From: Wolfenbarger, Jeanne
Sent: Thursday, February 26, 2015 4:38 PM
To: 'aecllc@aol.com'
Subject: H13-D021 (Starbucks and Burger King)
Attachments: Scanned from a Xerox multifunction device.pdf; Scanned from a Xerox multifunction device (32).pdf

Shawn, as discussed earlier, go ahead and revise the TCL to add a ramp on each end of the pedestrian way from the handicapped spot in the middle of the parking lot (as shown per first attachment).

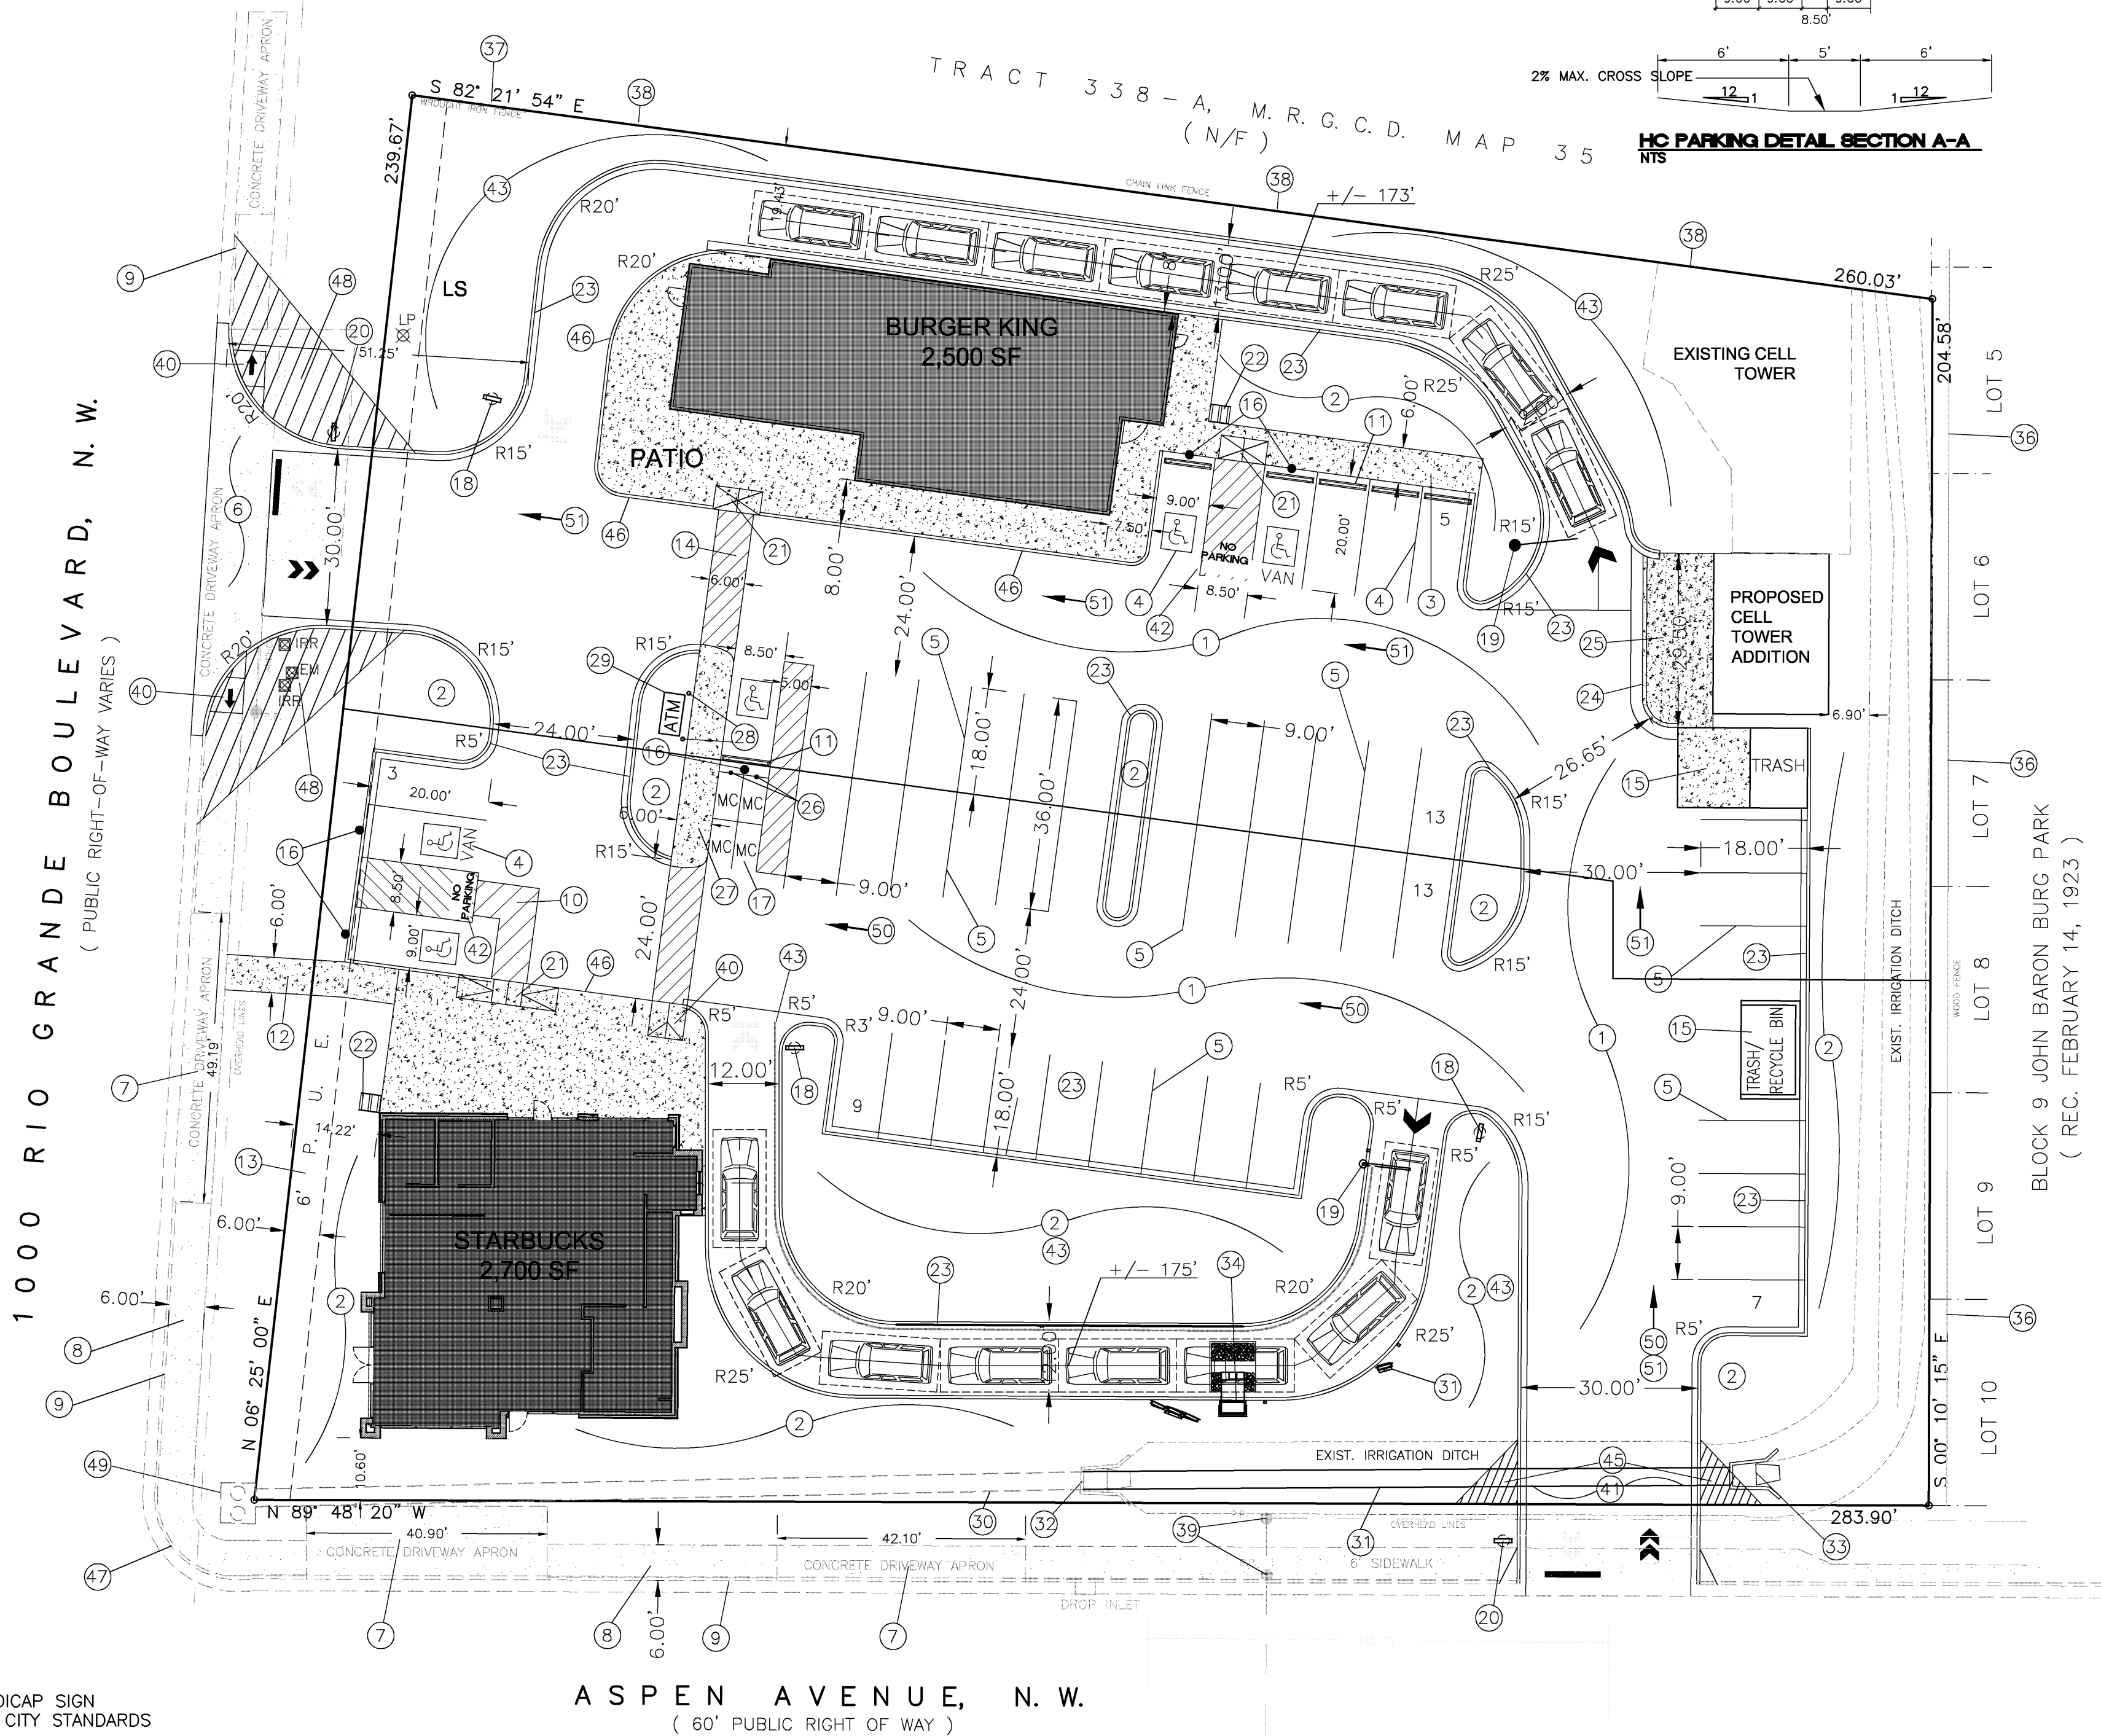
As per the second attachment, make sure that the curb ramp shows a maximum 2% cross-slope on the ramp.
